**RE: PUBLIC NOTIFICATION OF SSD-23588910 – PROPOSED MIXED USE
DEVELOPMENT AT NOS. 26-30 MANN STREET, GOSFORD (LOT 111
DP 1265226; LOT 469 DP 821073 & LOTS 2-7 DP 14761 - ‘CENTRAL COAST
QUARTER – STAGE 1, NORTHERN TOWER’).**

I refer to the public notification of SSD - 23588910 for construction of a 25 storey mixed use retail/residential development (‘Central Coast Quarter – Stage 1, Northern Tower’) at Nos. 26 – 30 Mann Street, Gosford and make this submission on behalf of the owners (‘Rola Property Group’) of a neighbouring site at Nos. 27-37 Mann Street and No. 125 Georgiana Terrace, Gosford, which has the benefit of operational Development Consent 46209/2014 for a 19 storey mixed use development on that site.

View Loss Analysis Plan 1/2
SKo3
A

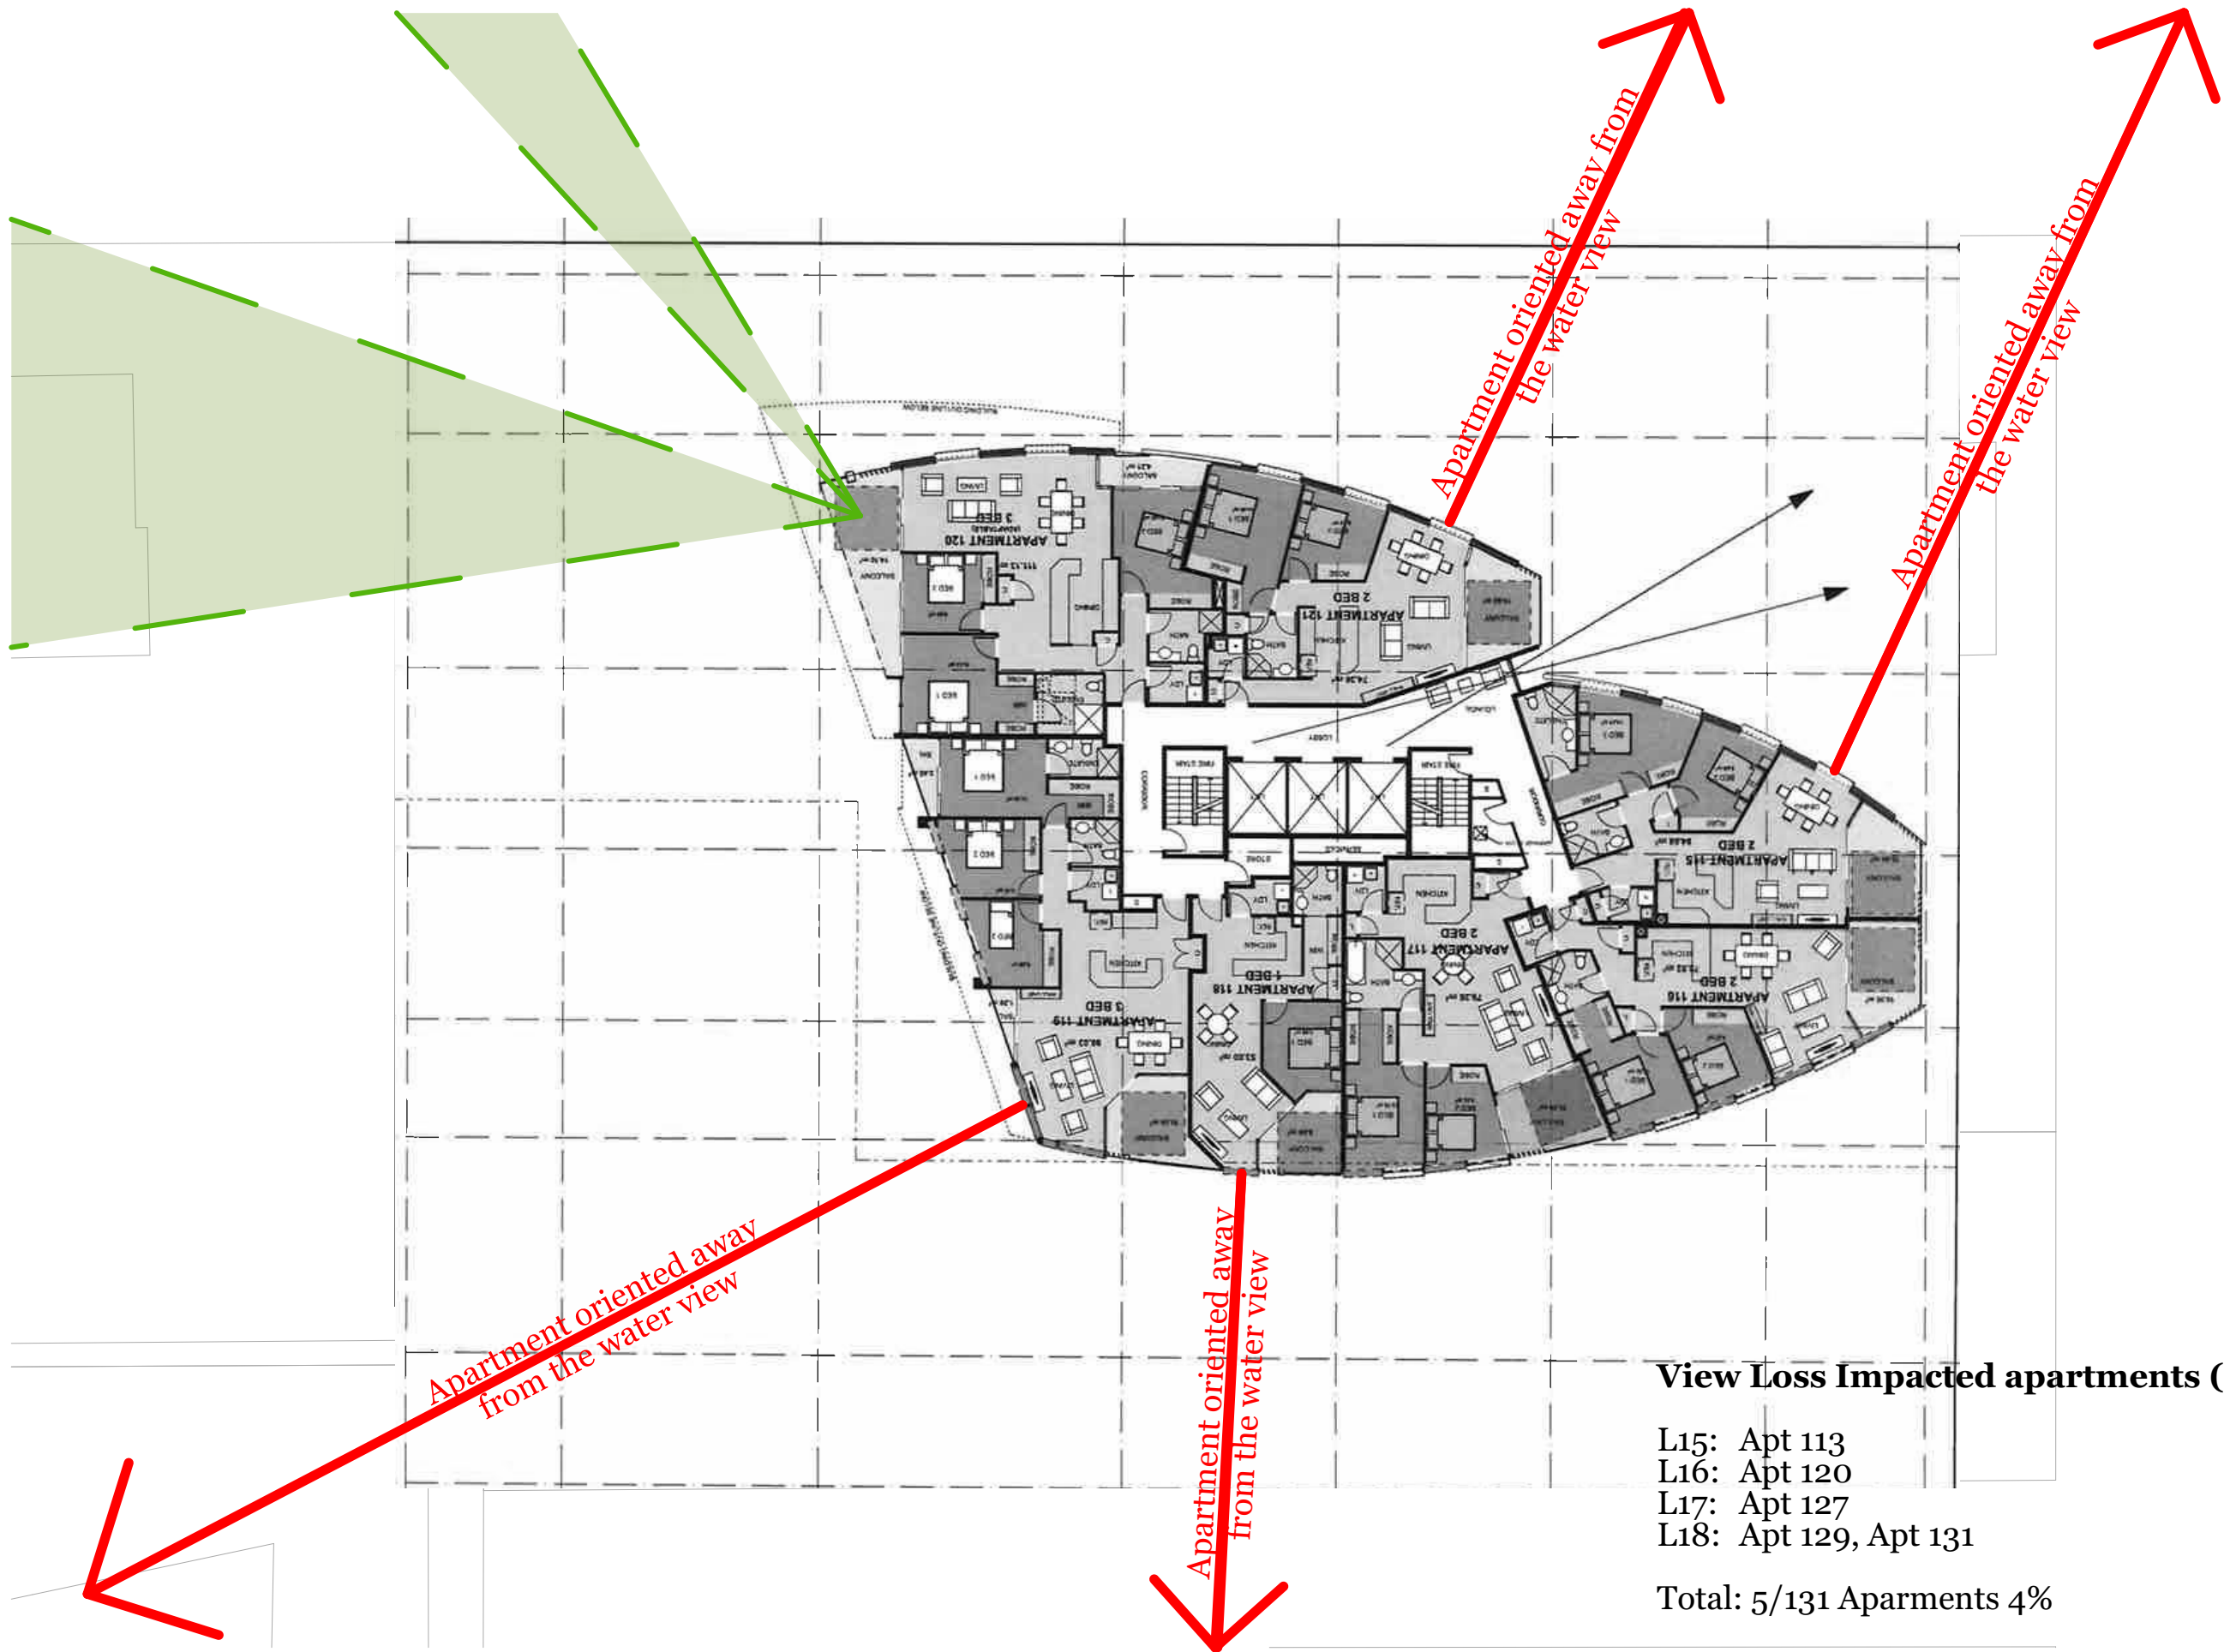
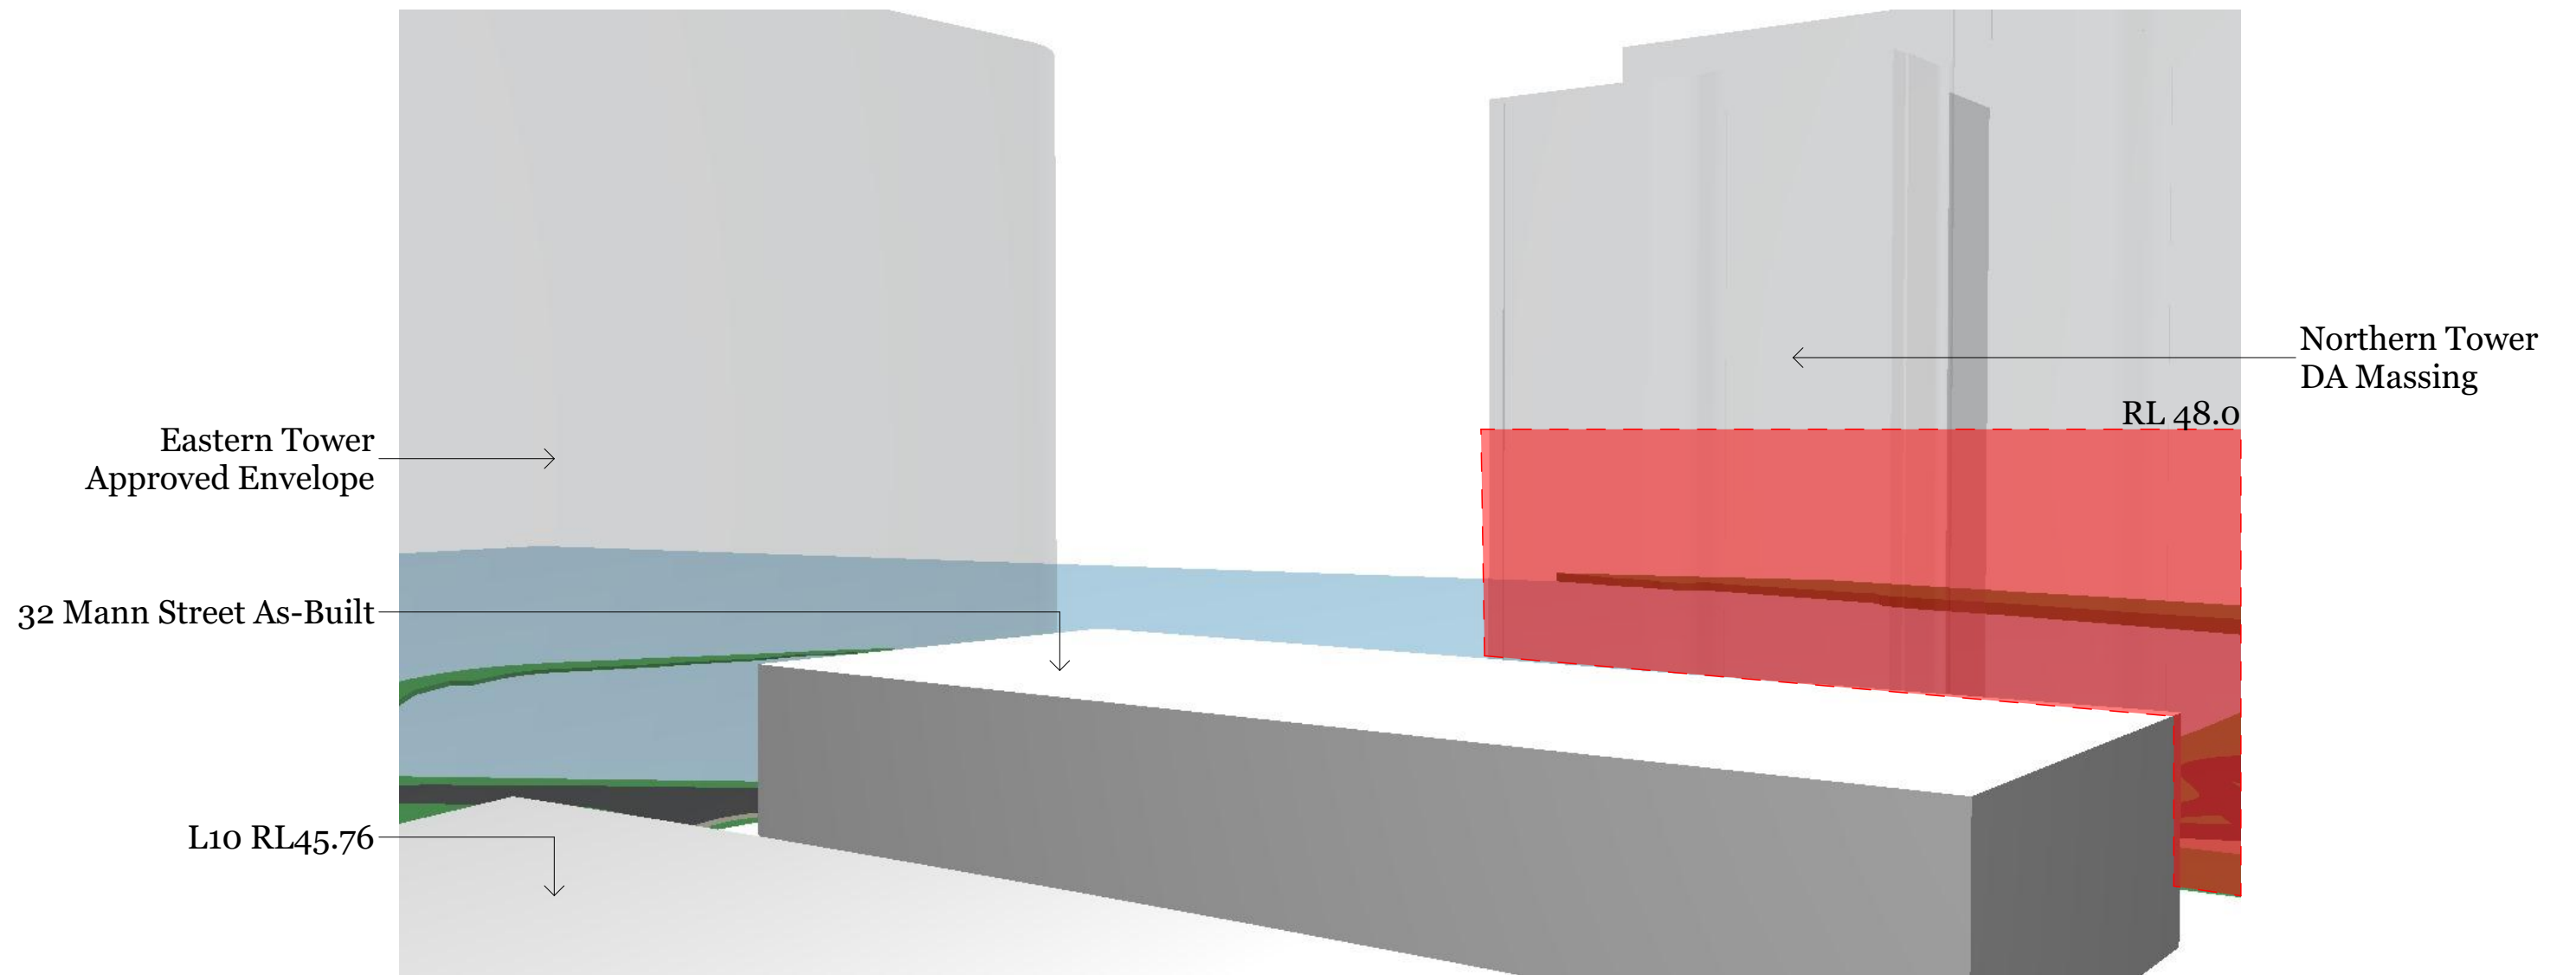
Review of the publicly exhibited supporting consultant documents reveals that SSD-23588910 provides no assessment of the severe view loss that would be experienced by the approved development at Nos. 27-37 Mann Street under Consent 46209/2014, if SSD-23588910 is approved:

- The topmost floor height of the development approved at Nos. 27-37 Mann Street, Gosford under Consent 46209/2014 is RL 68.640m. In comparison, the proposed maximum building height under SSD-23588910 is RL 81.4m, some 12.76m higher than the topmost floor height at Nos. 27-37 Mann Street. This will result in severe loss of highly valued Brisbane Water and escarpment views from the approved development at Nos. 27-37 Mann Street, which will be further exacerbated by the cumulative impact of the tower building envelopes approved under SSD 10114 (Northern Tower – up to RL 81.4m; Southern Tower – up to RL 65.1m; and Eastern Tower – up to 71.3m);
